TO: Halcyon Homes
P.O. Box 33578
Raleigh, NC 27636-3578

PROJECT #: 22-1682-A

LOCATION: Lot 28, Prince Place

PLANS REF: Lot 28, Prince Place by Murphy Garnow Design Group Project #: 22-1682

FIRST FLOOR PLAN
 SCALE:1/4" = 1'-0"

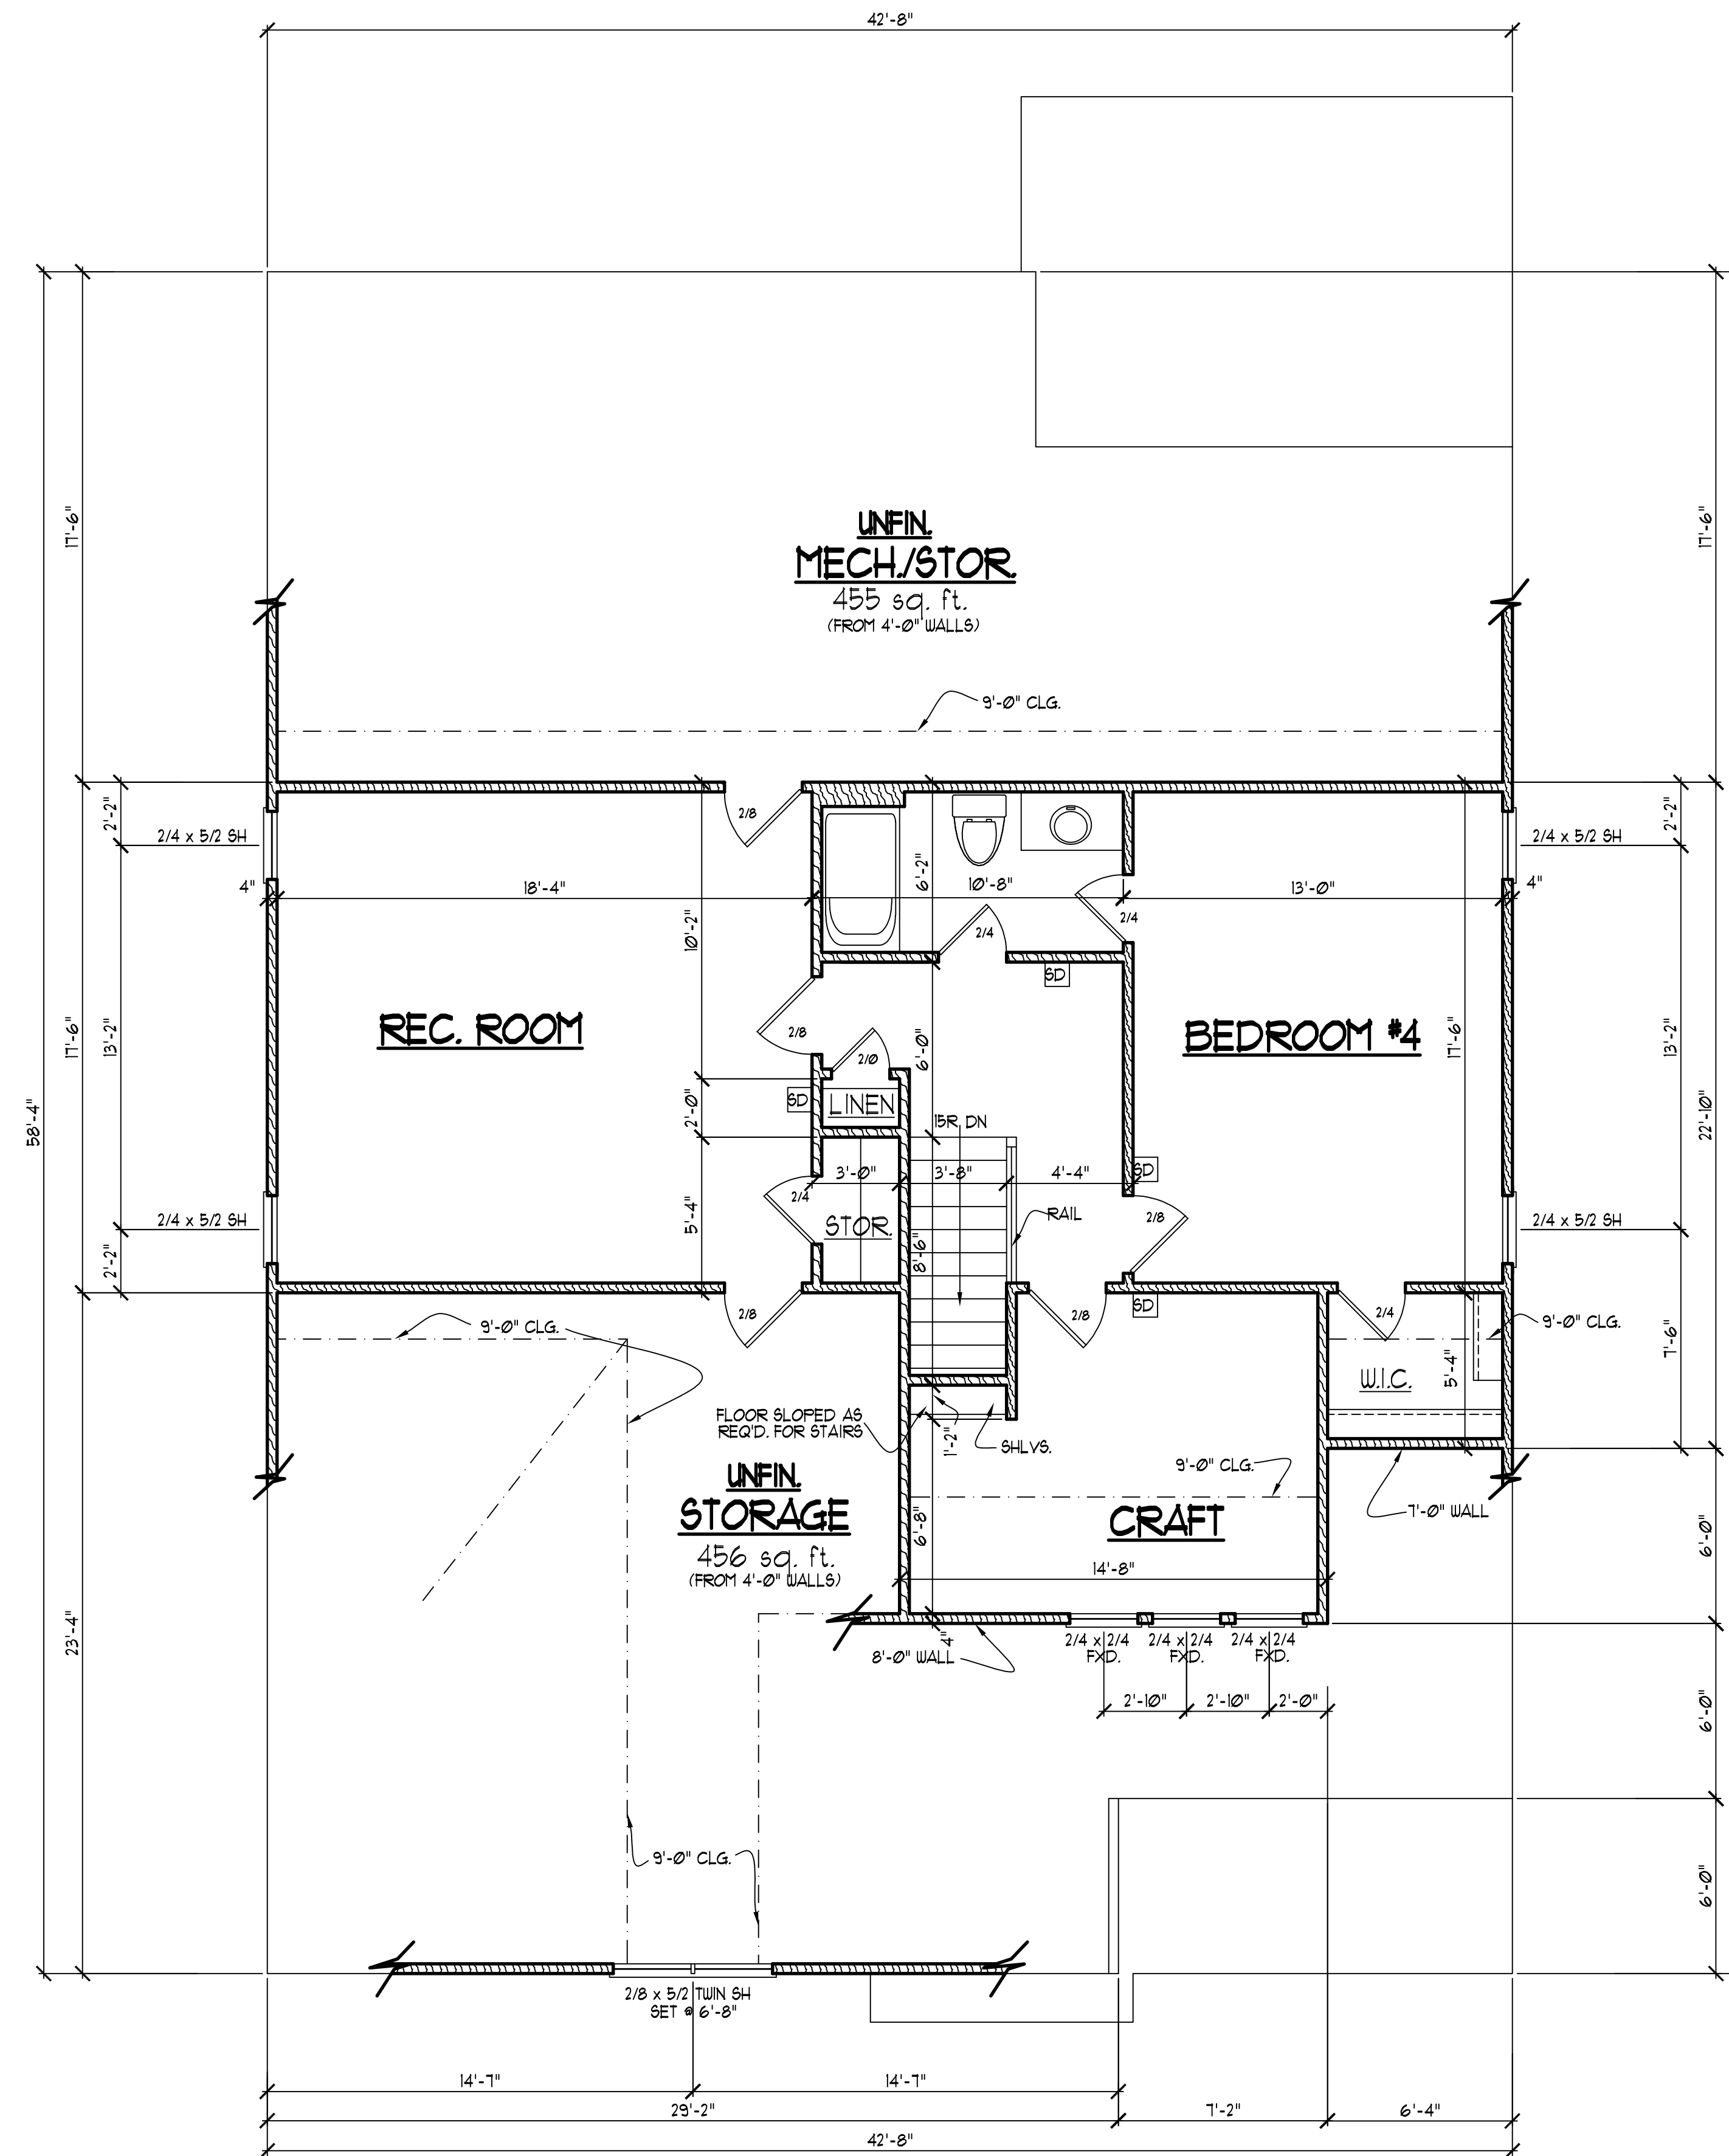
Missing King Stud: Based on information provided to Southern Engineers, there was not a continuous king stud between the W-16x31 main garage beam and the door to the mudroom. See page two of this letter for required straps and clips to compensate for the missing king stud.

FIRST FLOOR CEILING STRUCTURAL PLAN
SCALE: 1/4" = 1'-0"
3'-0" CLG. HGT.

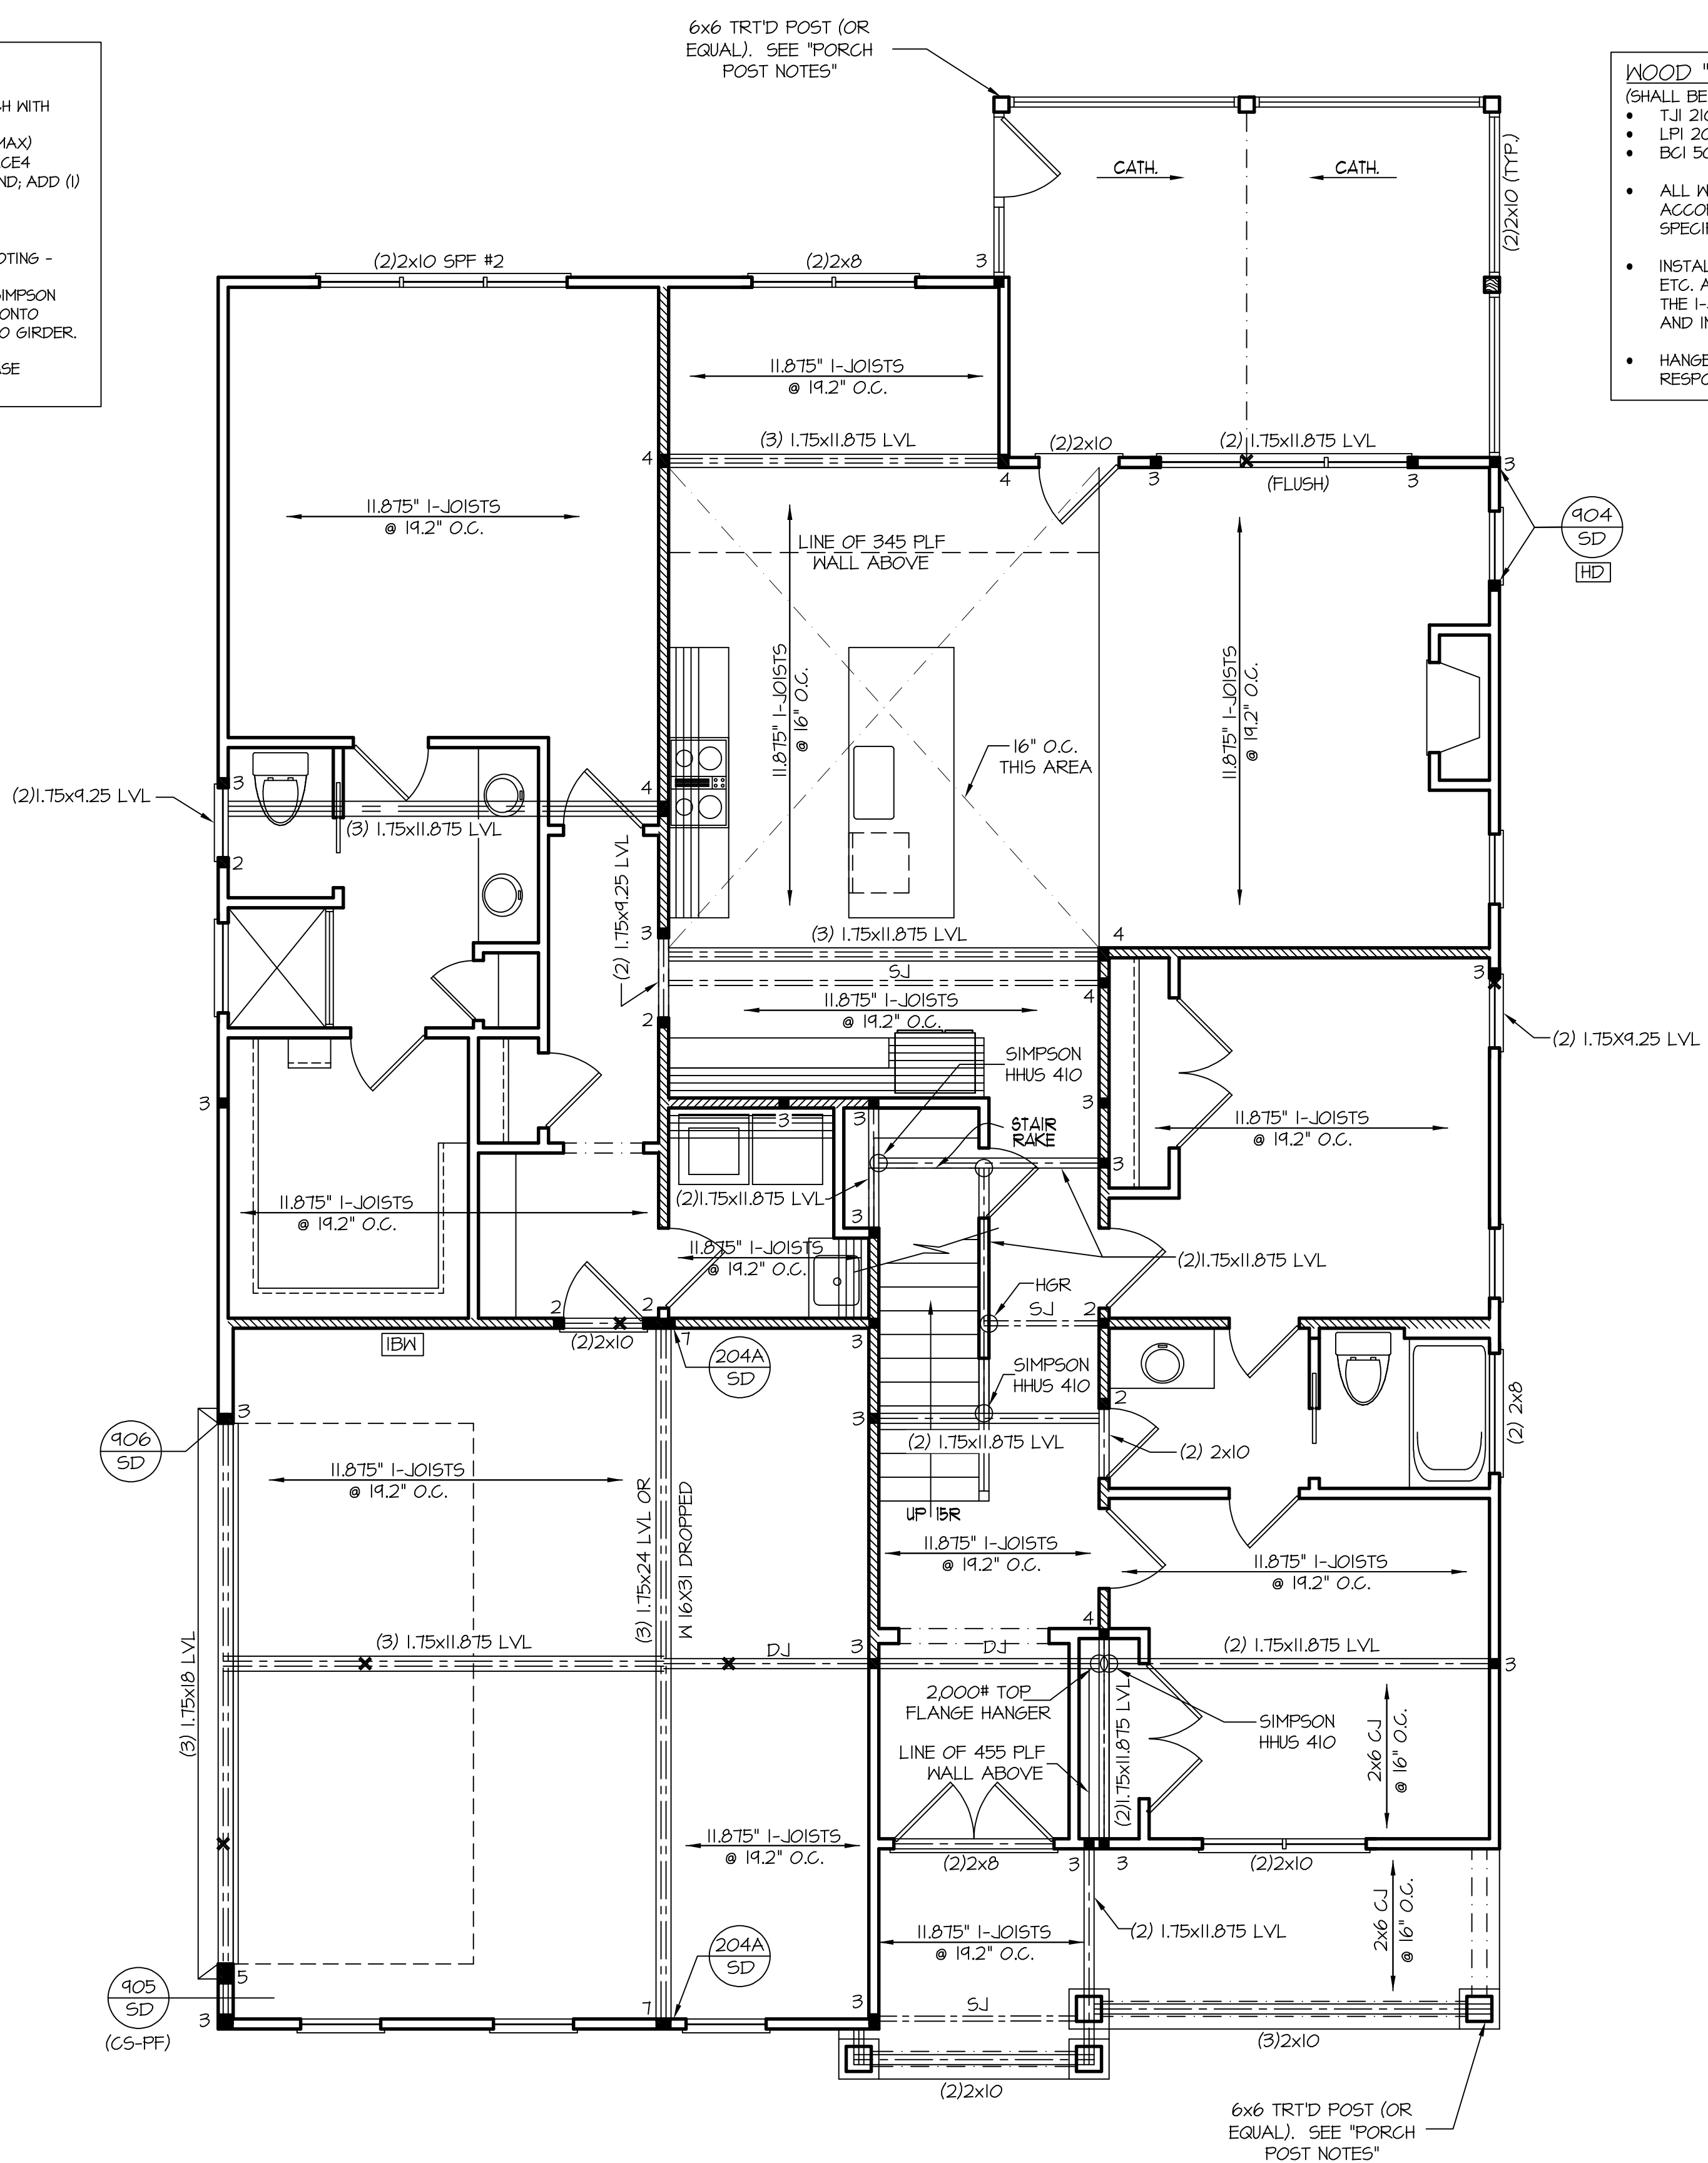
Notched Door Header: Sheet 6 of the plans shows a (2)2x10 header above the door between the Family Room and the Screened Porch. Based on information provided to Southern Engineers, the header was notched 1½” out of its bottom edge due to the door height. Please note that the header is structurally acceptable with the noted notch.

Top Flange Hanger: Sheet 6 of the plans shows a 2000 LB capacity top flange hanger at the double I-Joist above the closet of Bedroom #2. Based on information provided to Southern Engineers, the I-Joists used are 2 ½” wide. Please note that a Simpson MIT311.88-2 or BA5.12/11.88 hanger is structurally acceptable.
